October 6, 2022

Re: Public Comment - File No. 2207-019
6950 SE Maker Street/Parcel No. 9350900620

AVERAGE BUILDING ELEVATION CALCS:

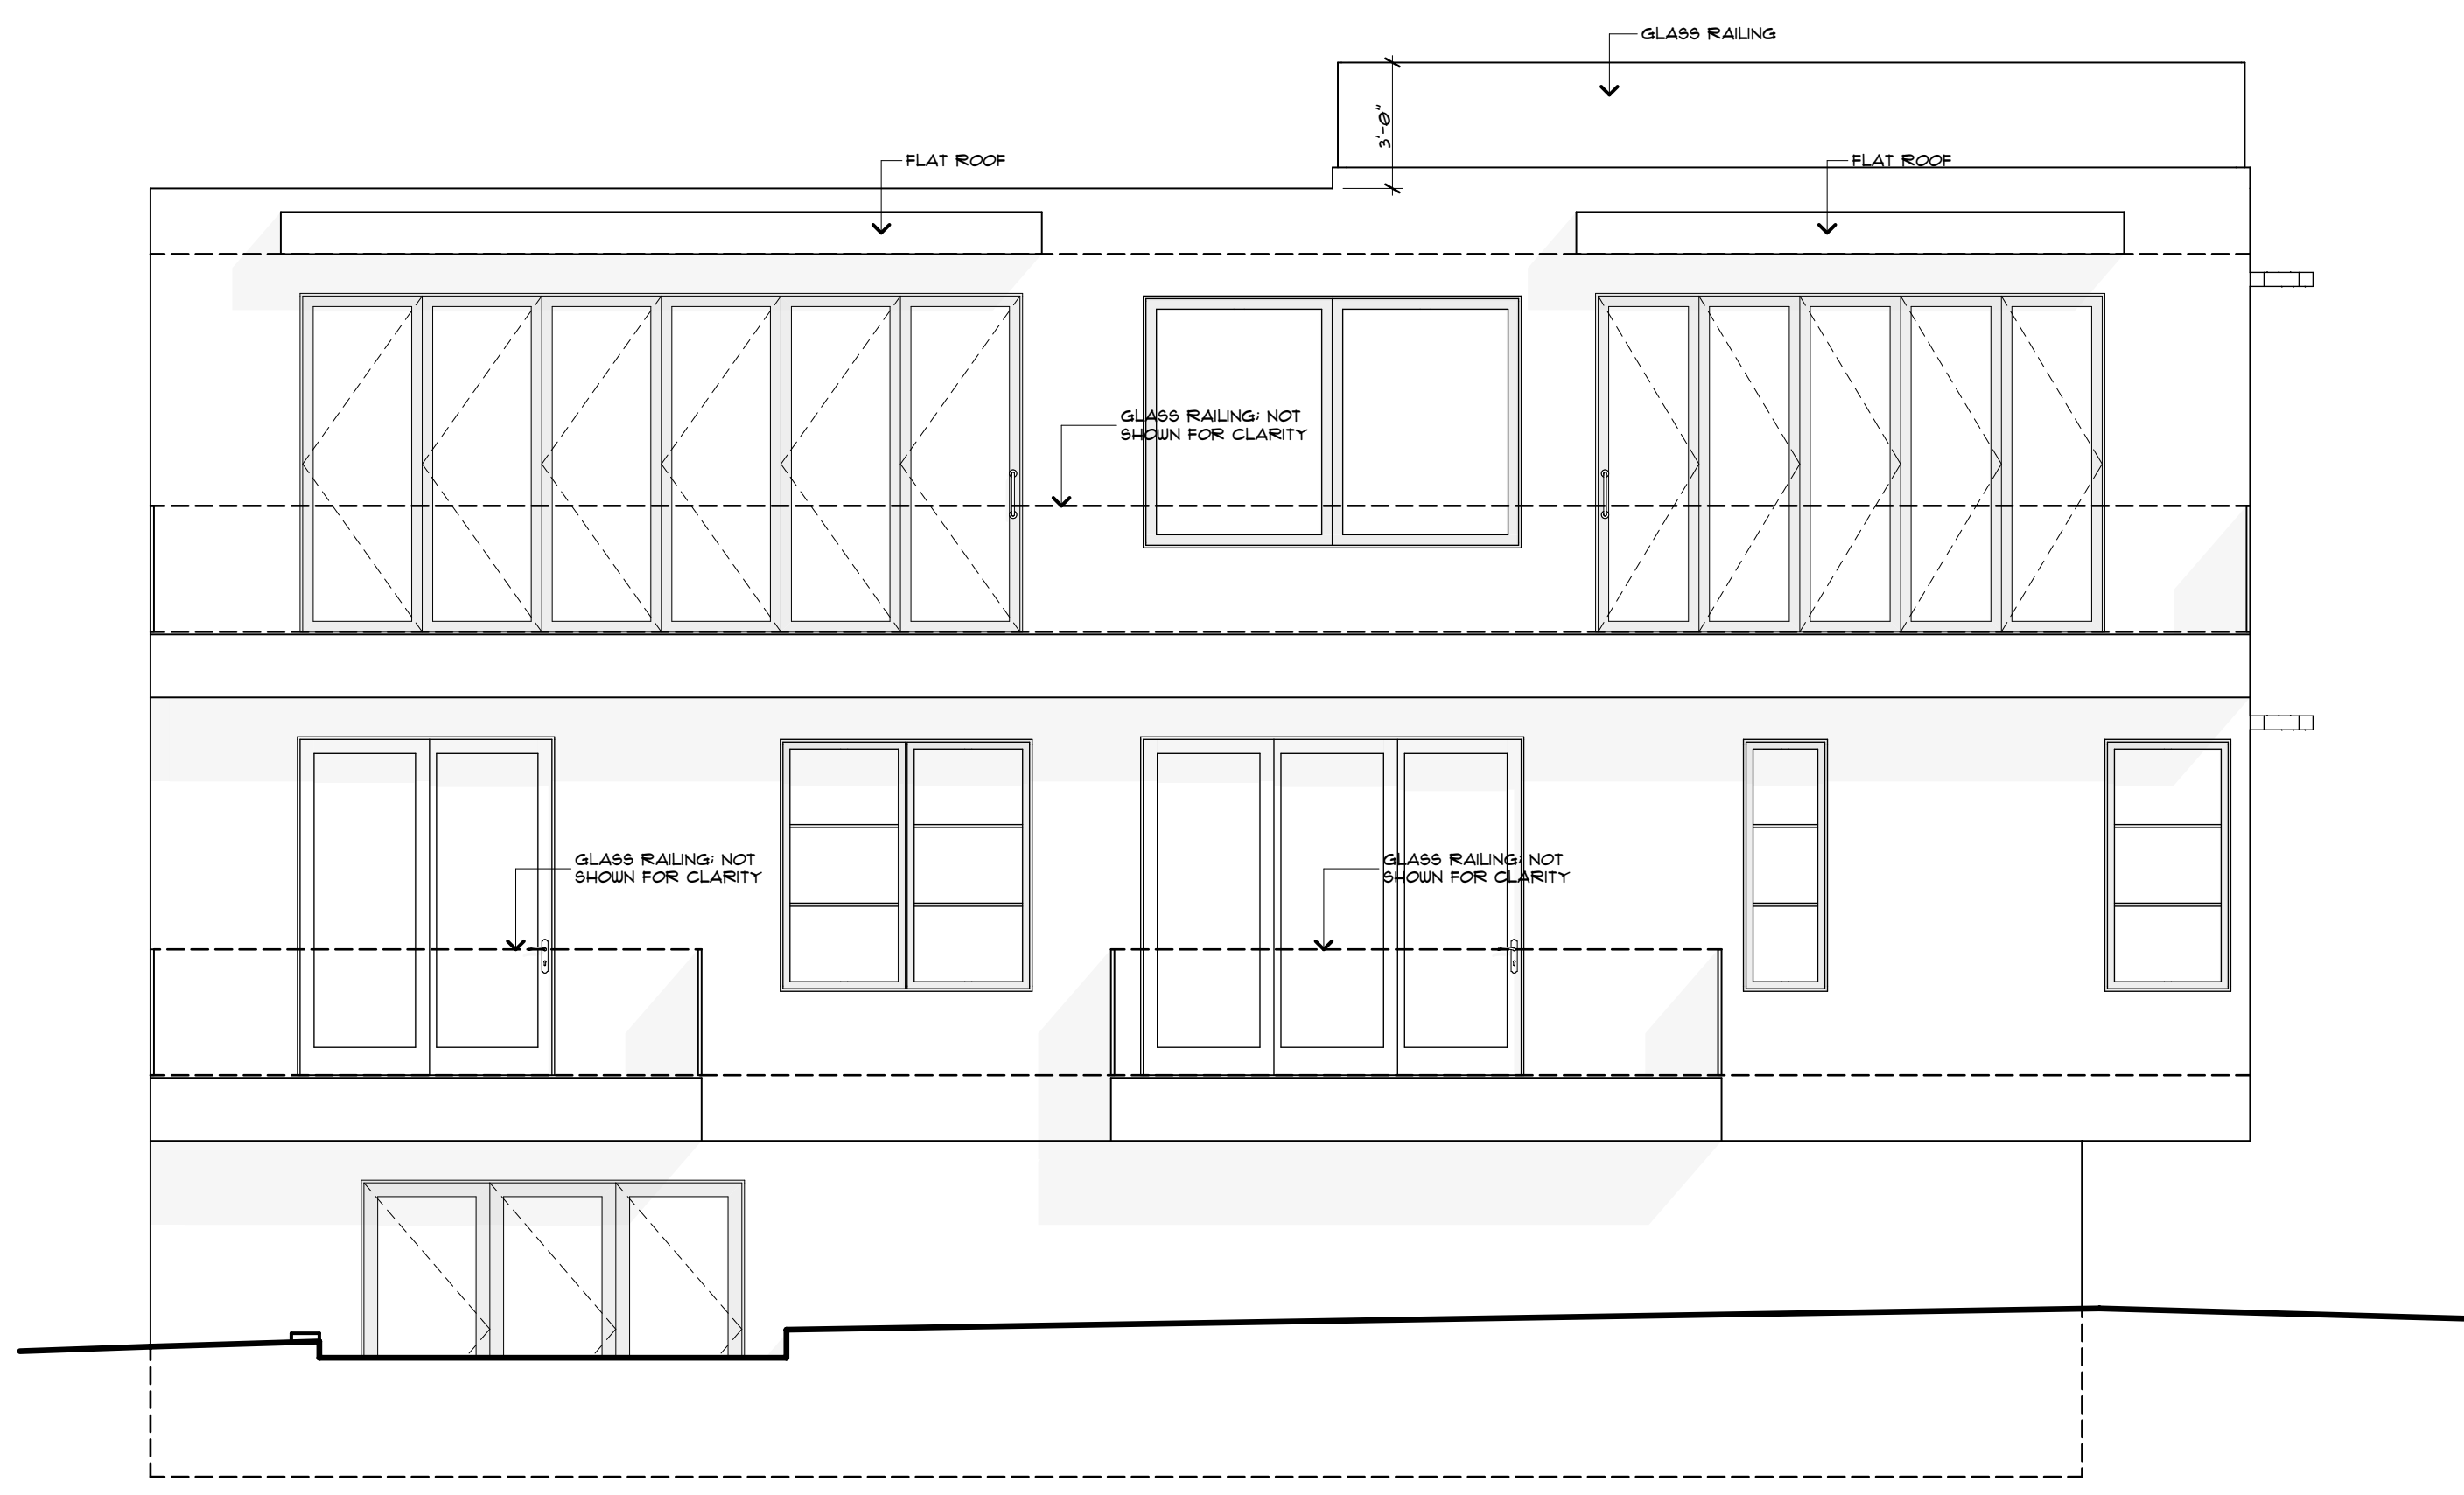
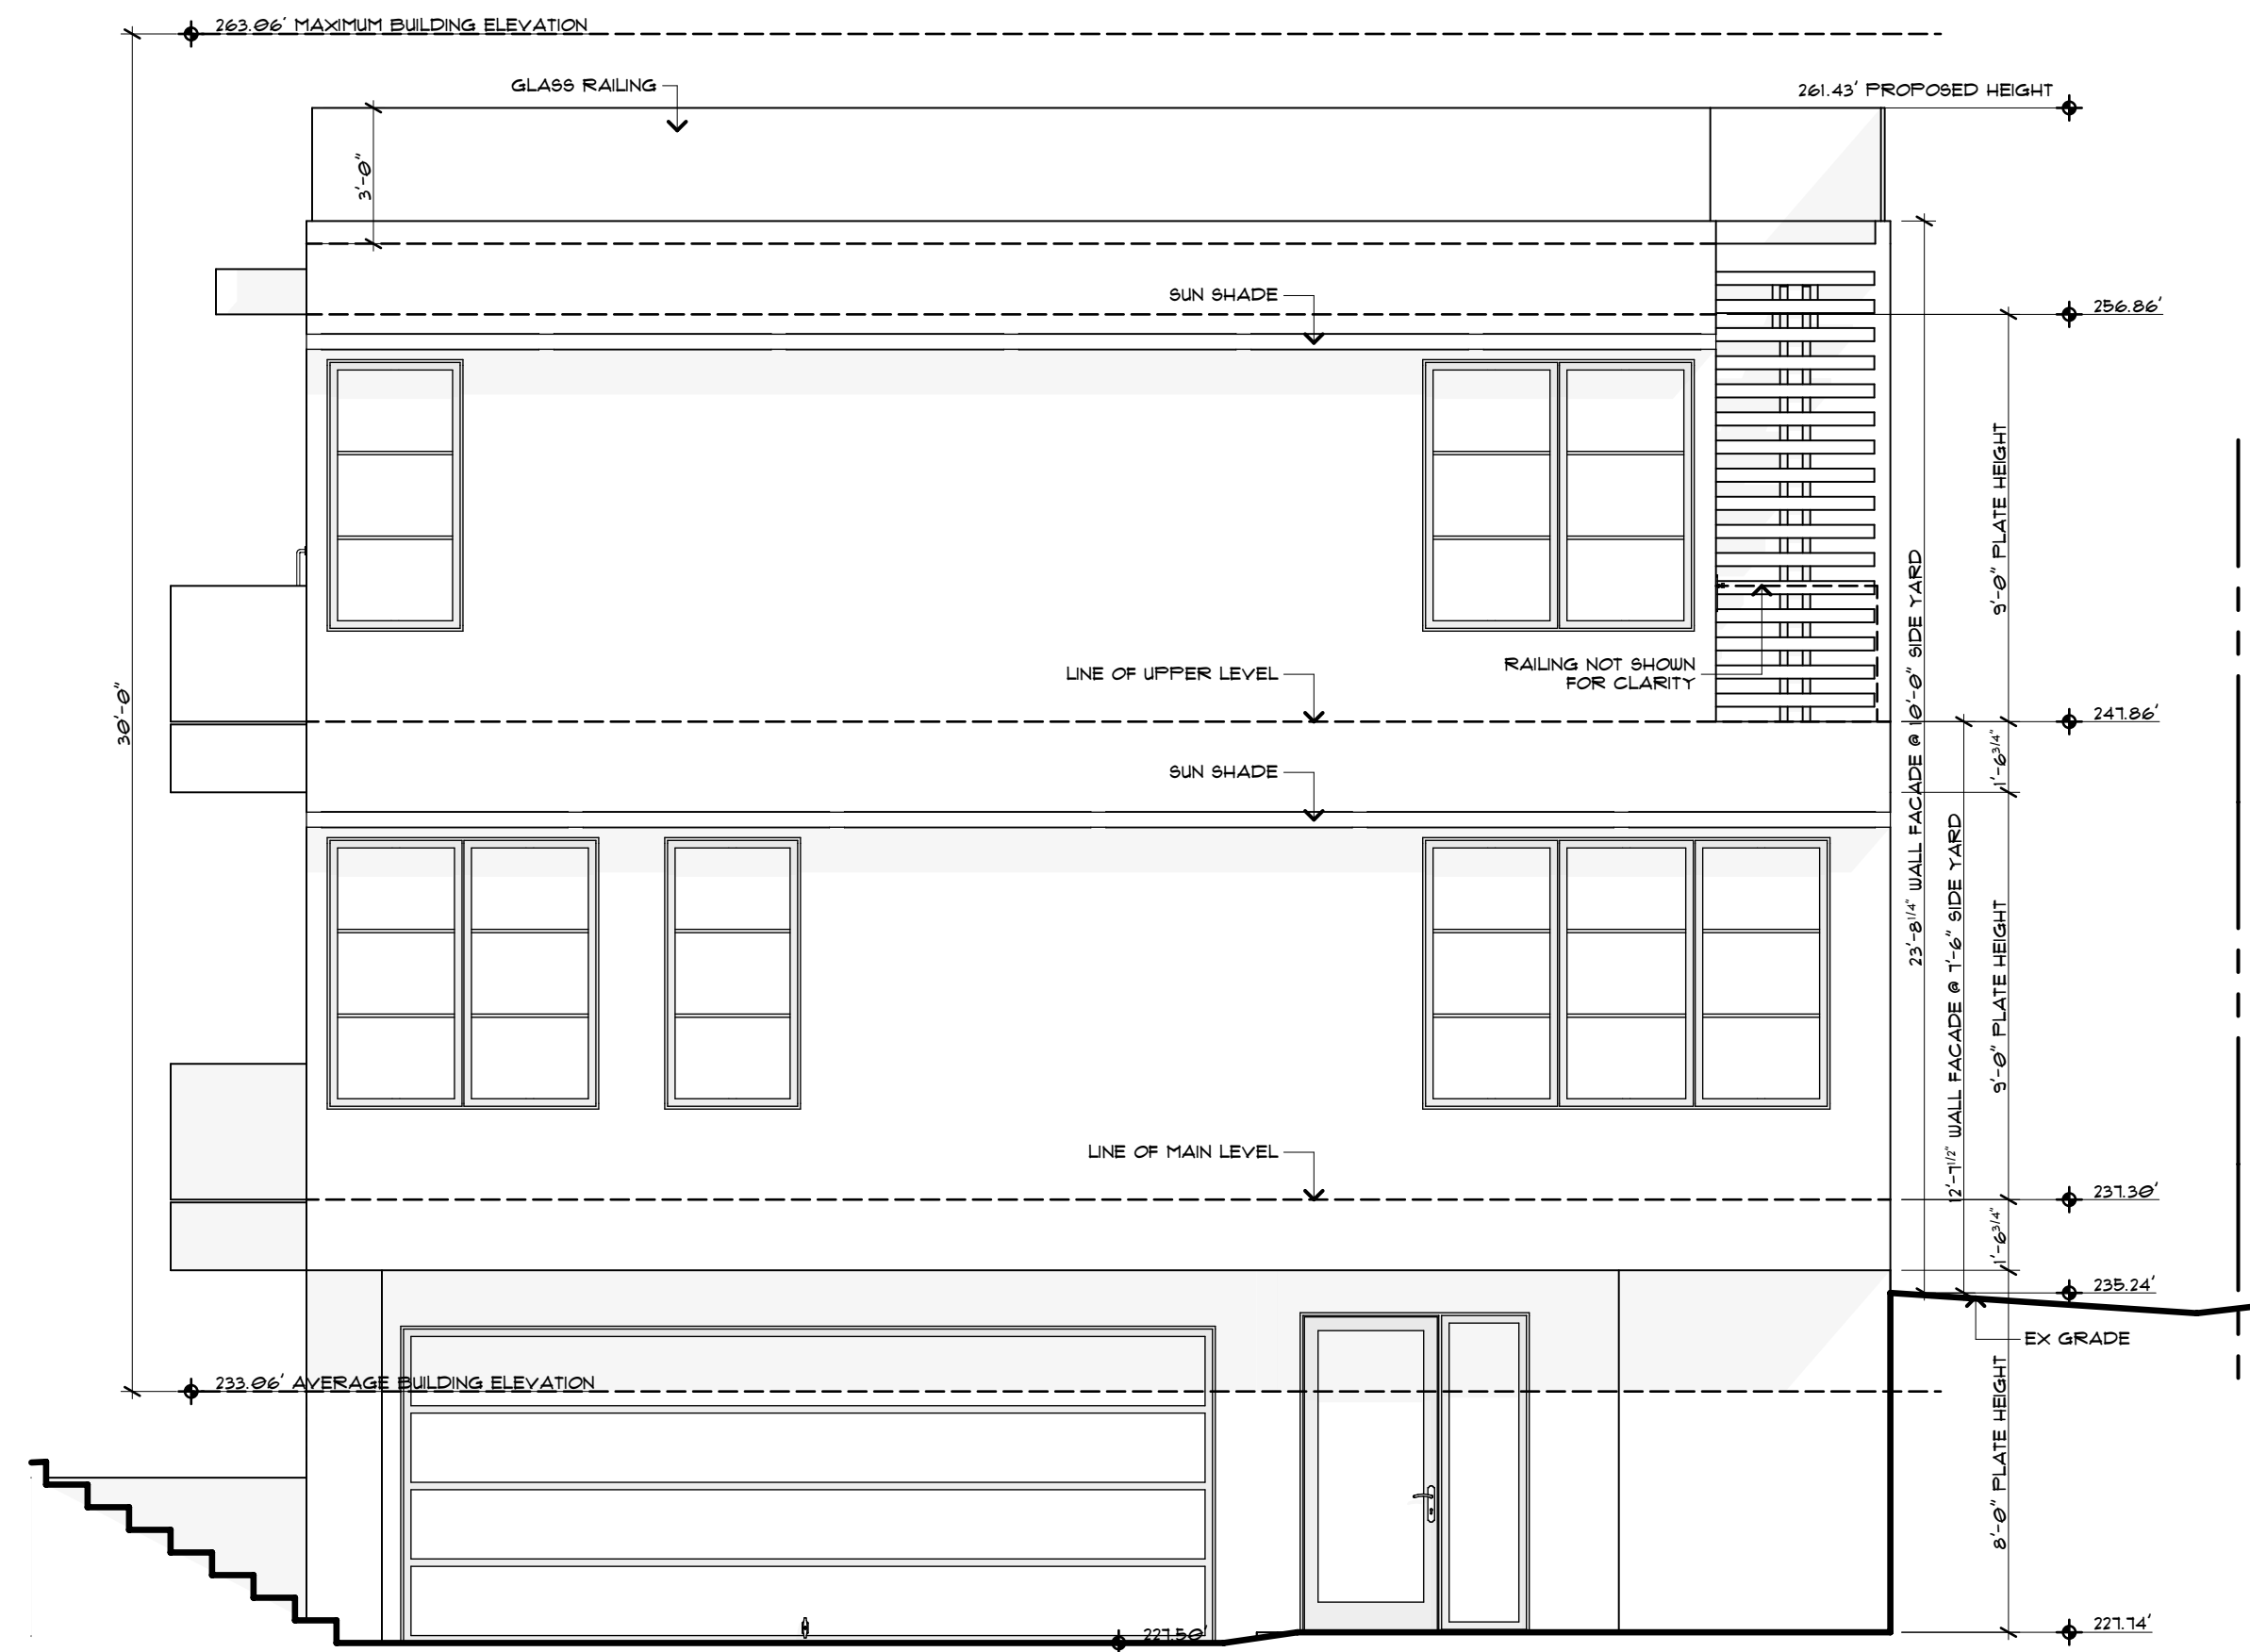
A. In particular, we share the concerns that the Project does not properly calculate the Existing Grade of the Site, as defined in MICC 19.16, in determining the permitted height for the Project. This results in a proposed residence that would be substantially taller than permitted by the MICC and would loom high above the rest of the homes in the neighborhood. We are also concerned that the rockery retaining walls that support a substantial amount of fill

Notwithstanding the substantial amount of fill located on the Site, the Proposal does not appear to use the Site's "Existing Grade," as defined by MICC19.16.010, to determine the permitted height of the proposed residence at the Site. Use of the appropriate Existing Grade, i.e., the grade prior to bringing a substantial amount of fill to the Site, would reduce the permitted height of the proposed residence by several feet, creating a structure less out of scale to the neighborhood and in compliance with the MICC.
